July 28, 2021

RE: Existing Tank Application # BRES2107-0027

An attempt was made to evaluate your property for the purpose of issuing an existing tank permit. The evaluation could not be completed for one or more of the following reasons.

Double 2x10 → Cantilever
To Do List

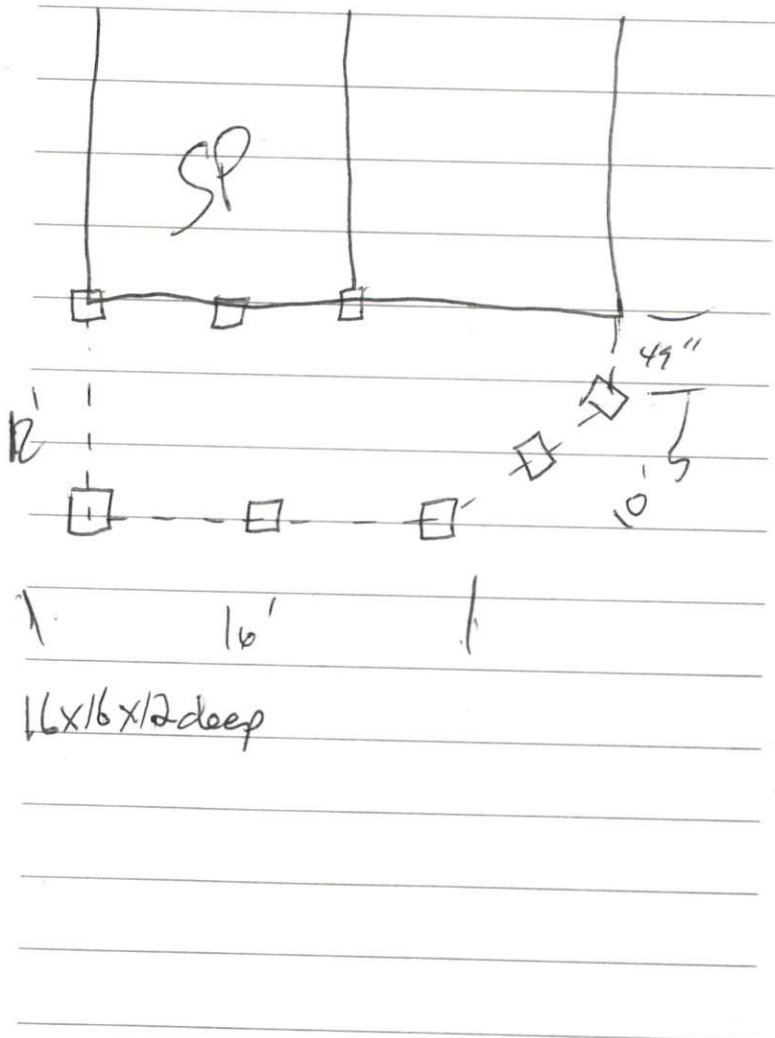
X 4. Other – Septic Encroachment – Proposed deck encroaches on septic setbacks. Adjacent drain field marked onsite and applicant notified to review paperwork accordingly with a 5ft deck foundation setback. Revise site plan and land use accordingly.
